# **EL PASO COUNTY PLANNING AND COMMUNITY DEVELOPMENT DEPARTMENT**

## **STORMWATER MANAGEMENT PLAN CHECKLIST**

Revised: July 2019

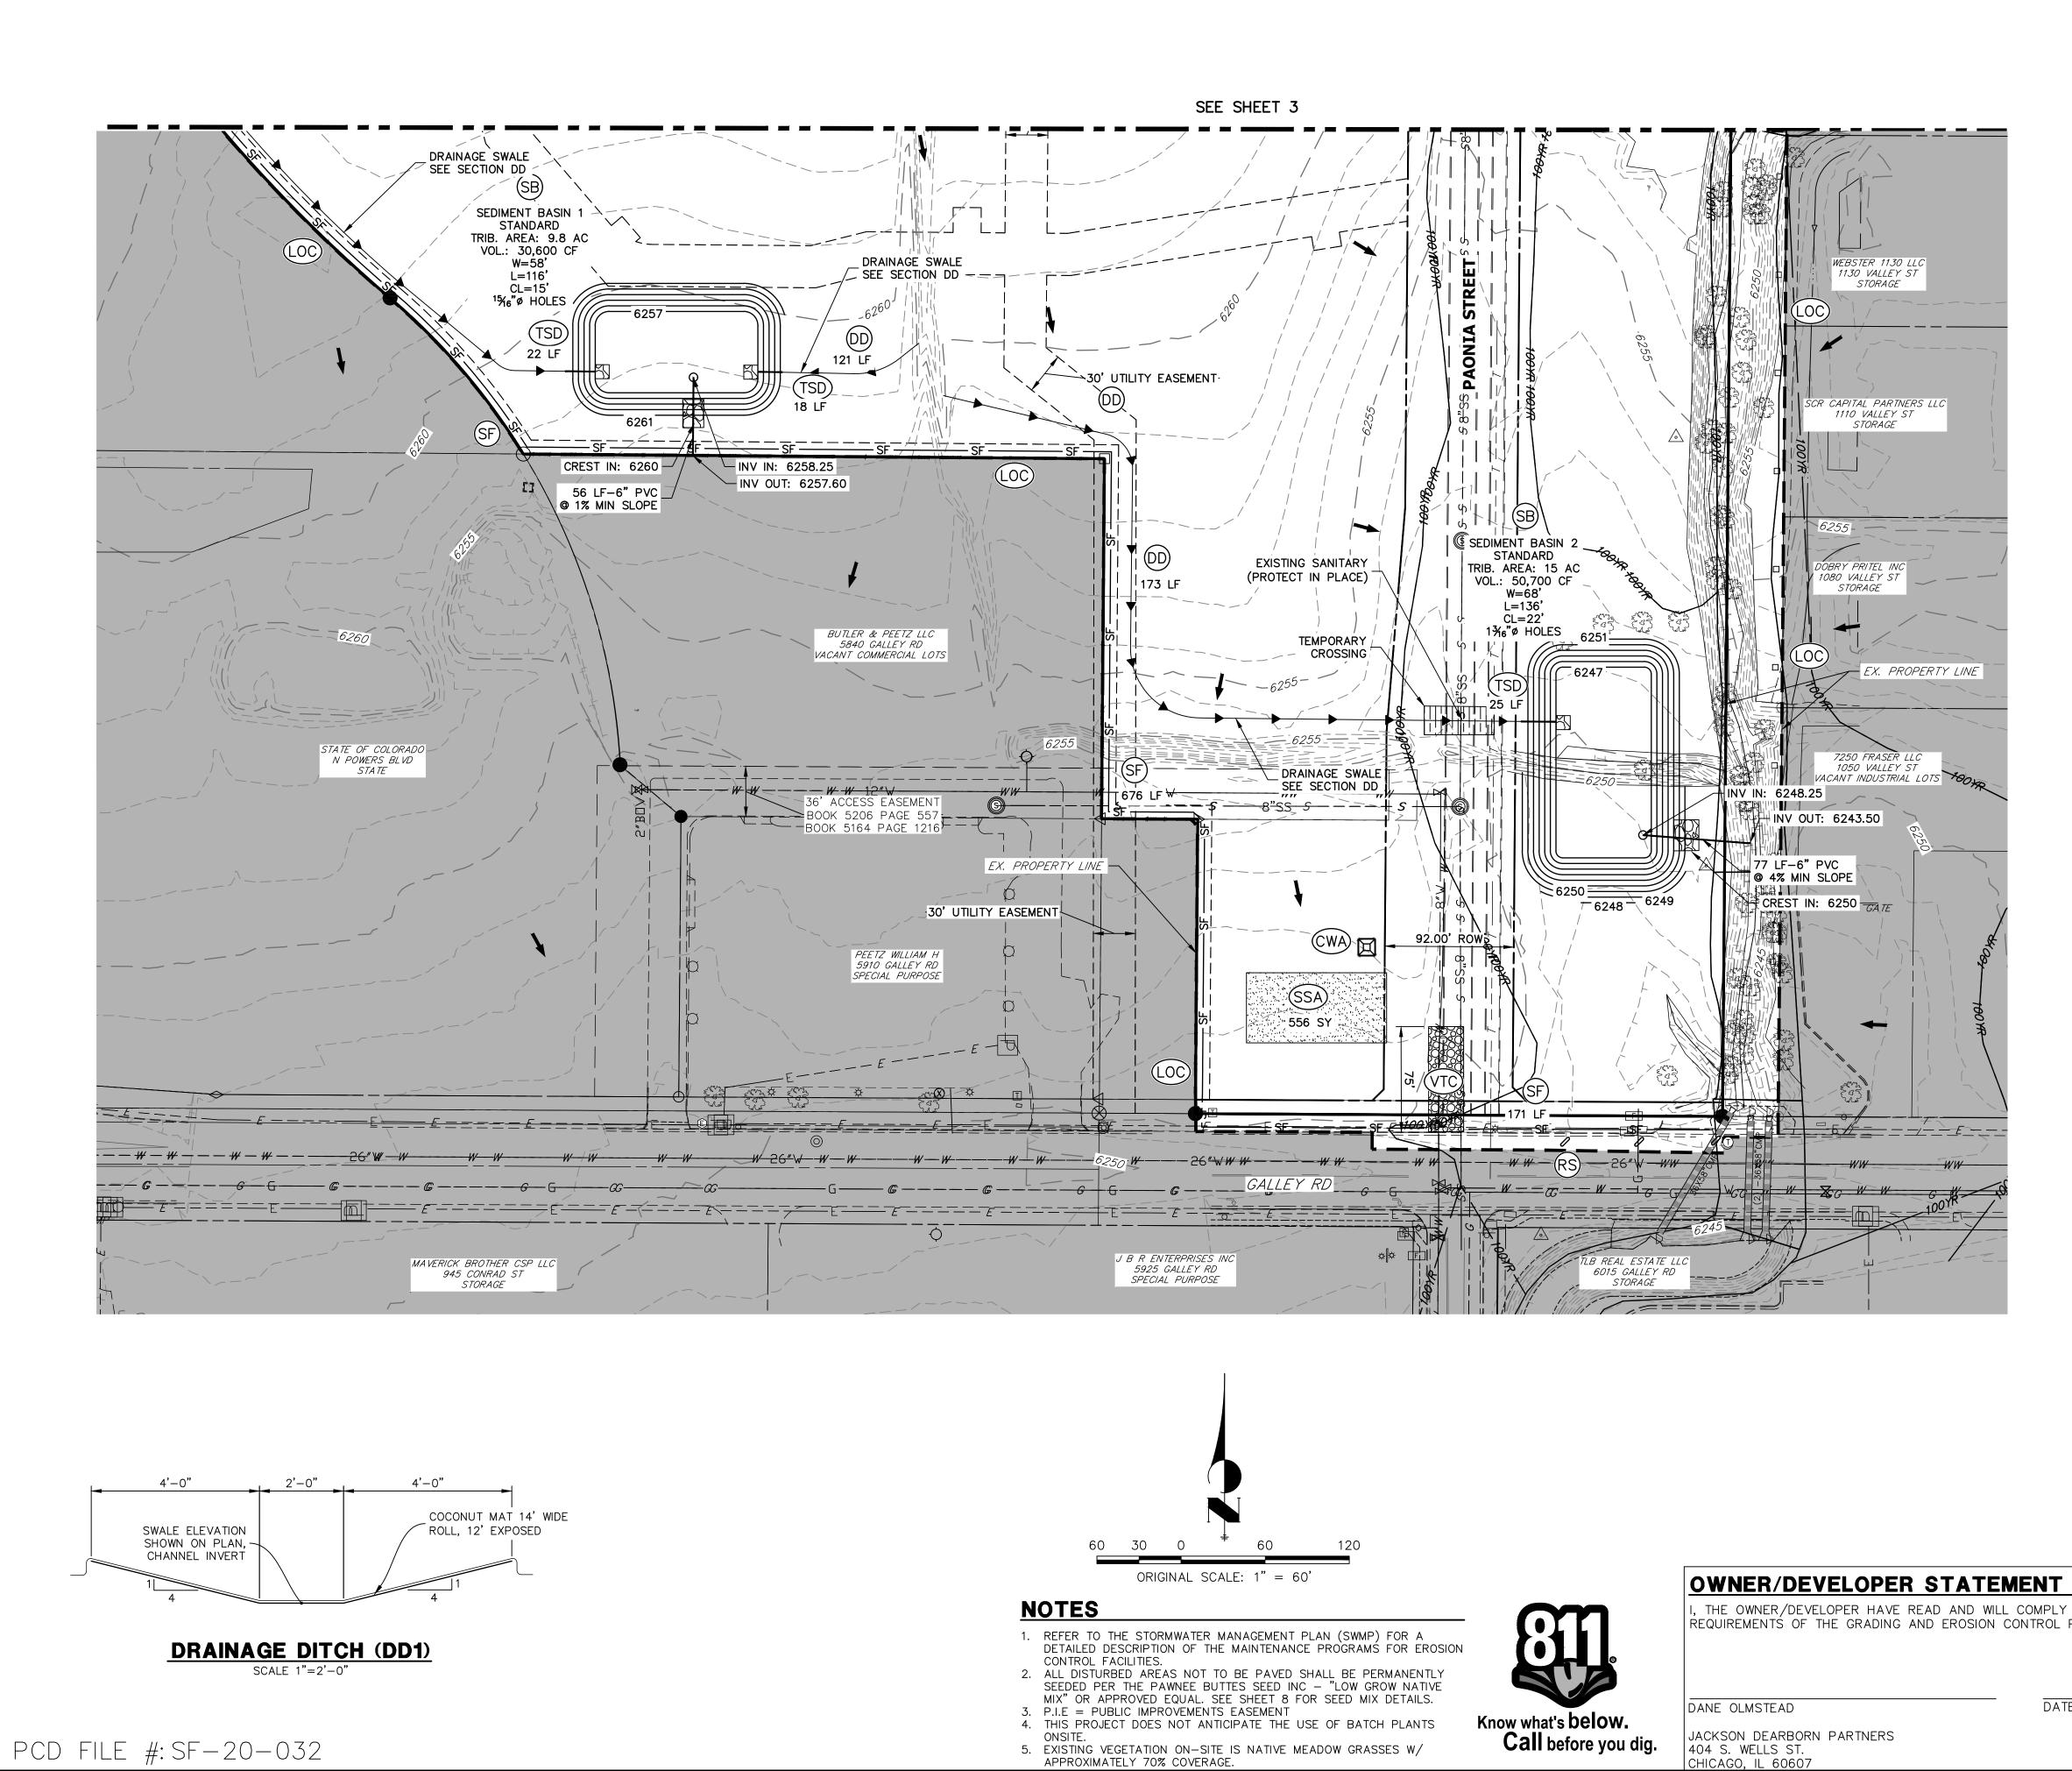
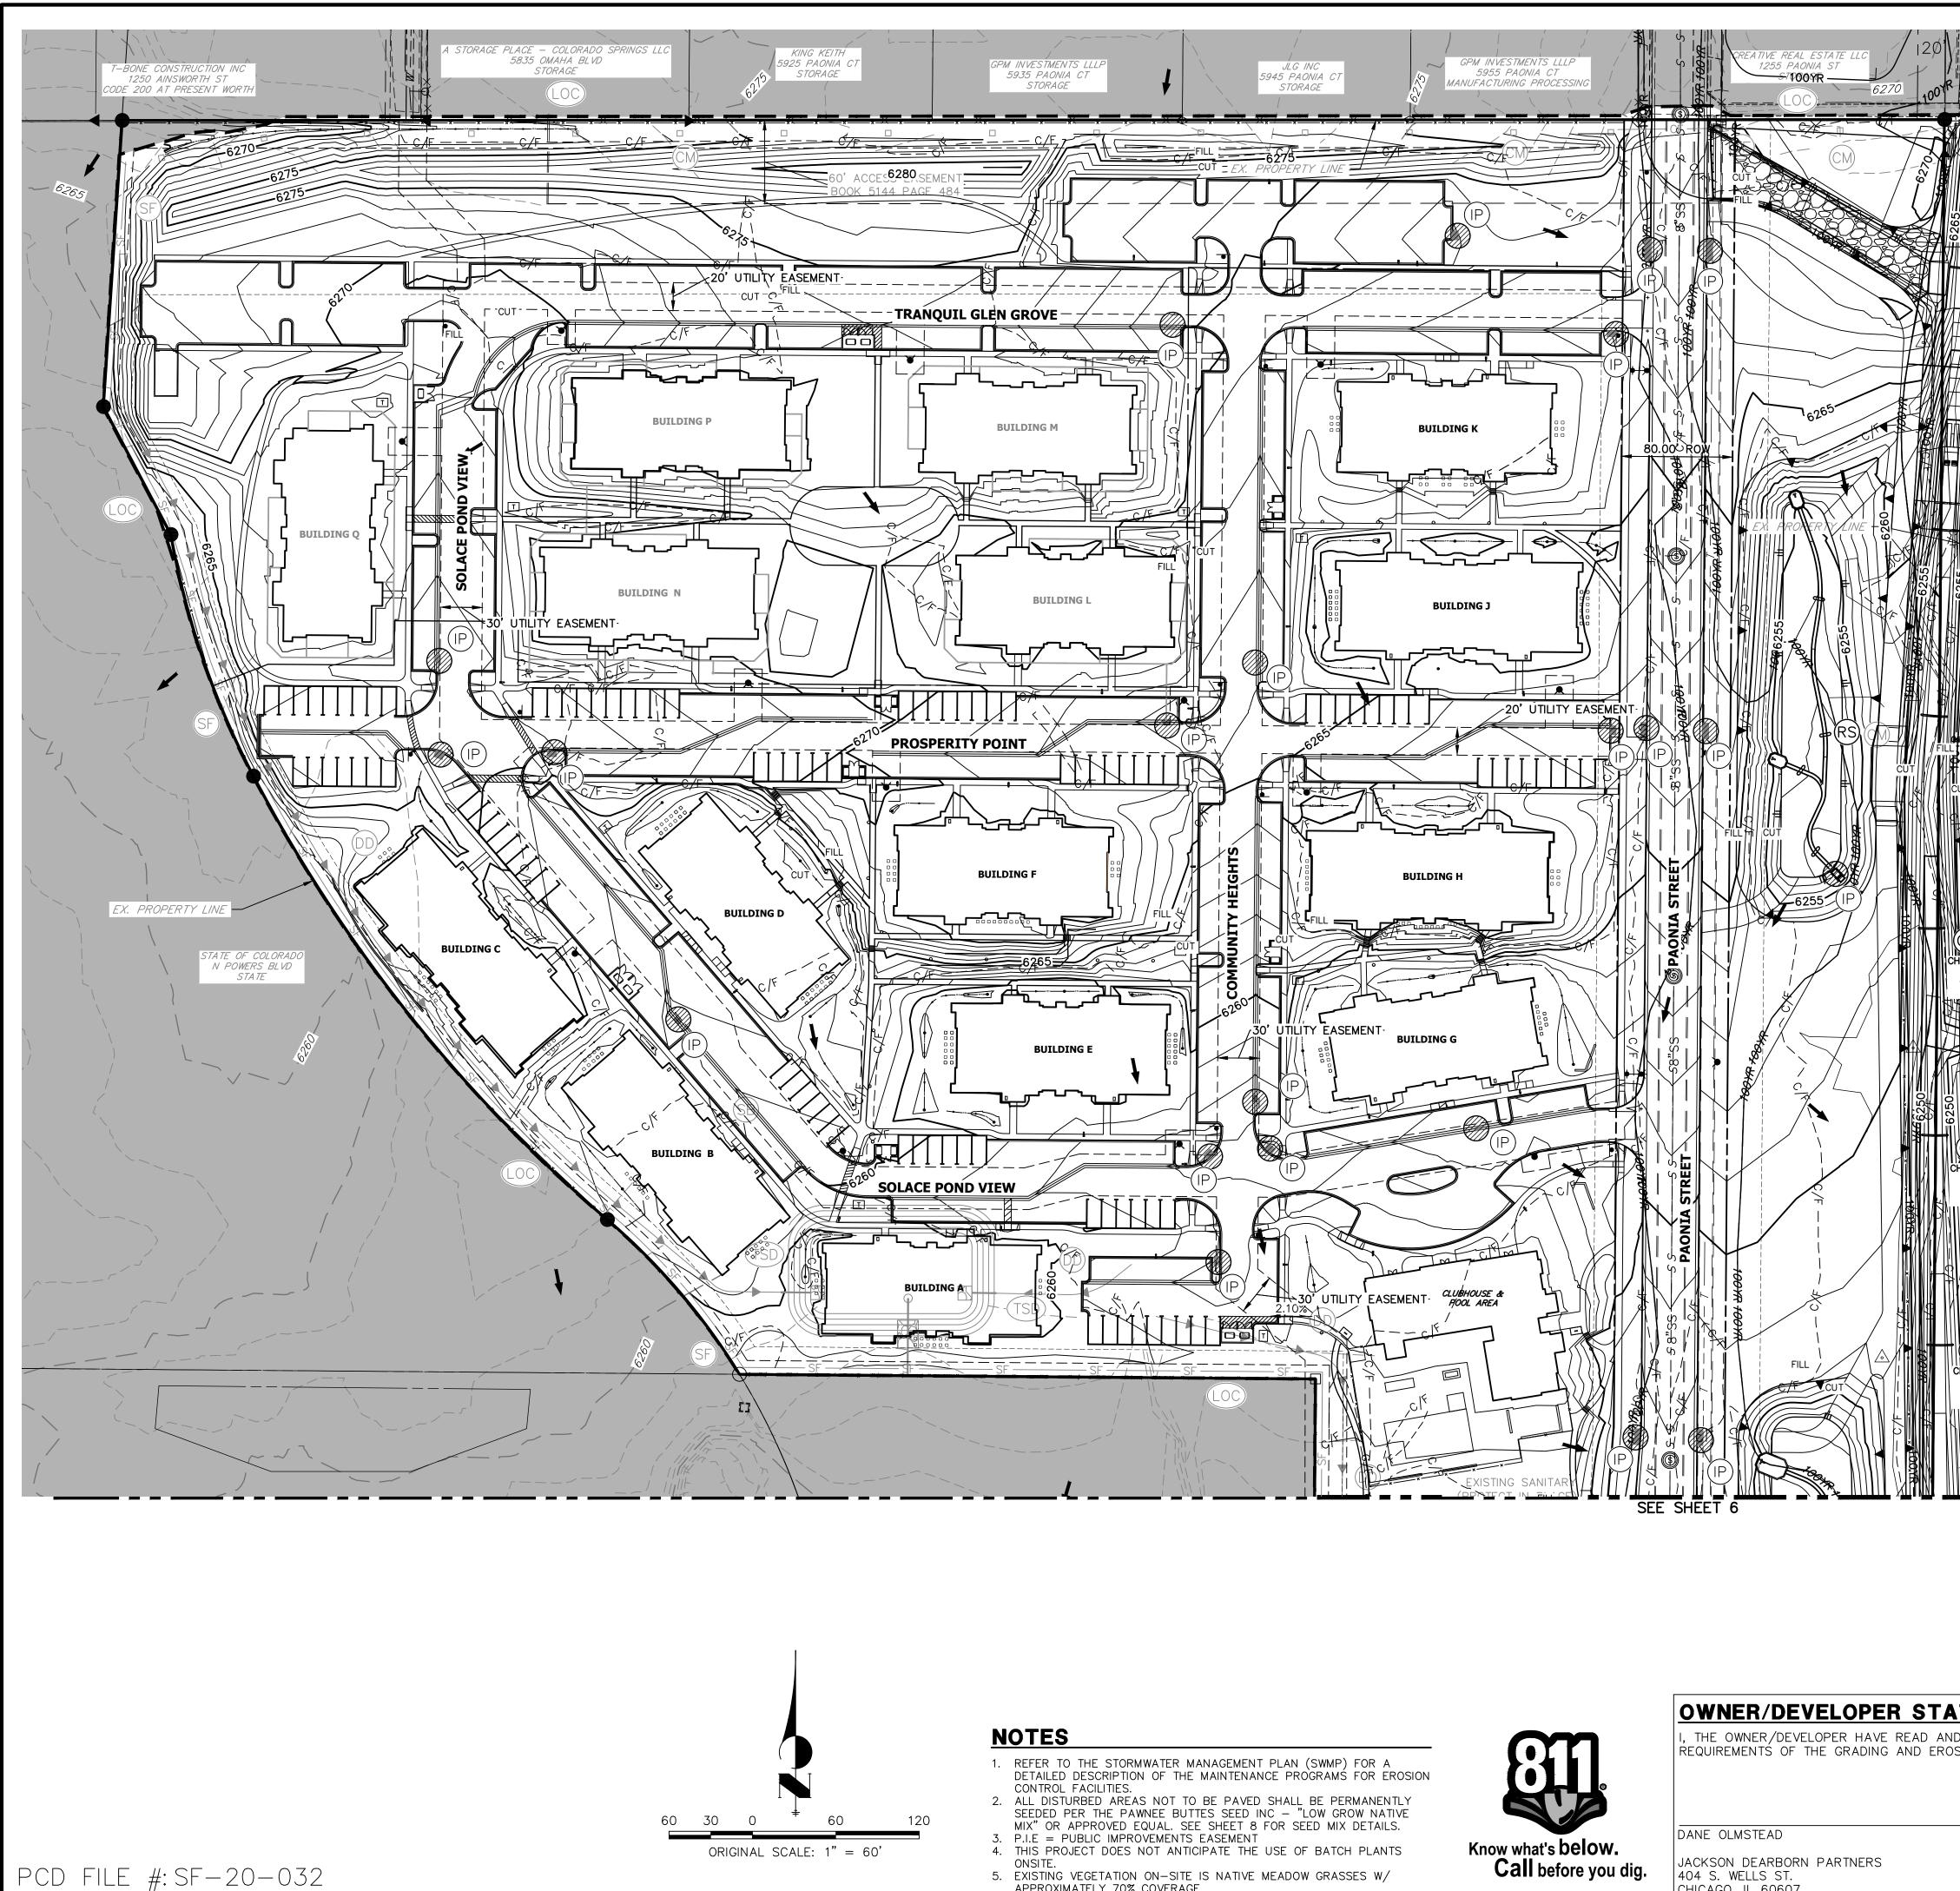
Revised: July 2019		Applicant	PCD
17	SWMP Map to include:	✓	
17a	construction site boundaries	✓	✓
17b	flow arrows to depict stormwater flow directions	✓	X
17c	all areas of disturbance	✓	X
17d	areas of cut and fill	✓	X
17e	areas used for storage of building materials, soils (stockpiles) or wastes	✓	✓
17f	location of any dedicated asphalt / concrete batch plants	✓	X
17g	location of all structural control measures	✓	✓
17h	location of all non-structural control measures	✓	✓
17i	springs, streams, wetlands and other surface waters, including areas that require maintenance of pre-existing vegetation within 50 feet of a receiving water	✓	✓
18	Narrative description of all structural control measures to be used. Modifications to EPC standard control measures must meet or exceed County-approved details.	✓	✓
19	Description of all non-structural control measures to be used including seeding, mulching, protection of existing vegetation, site watering, sod placement, etc.	✓	✓
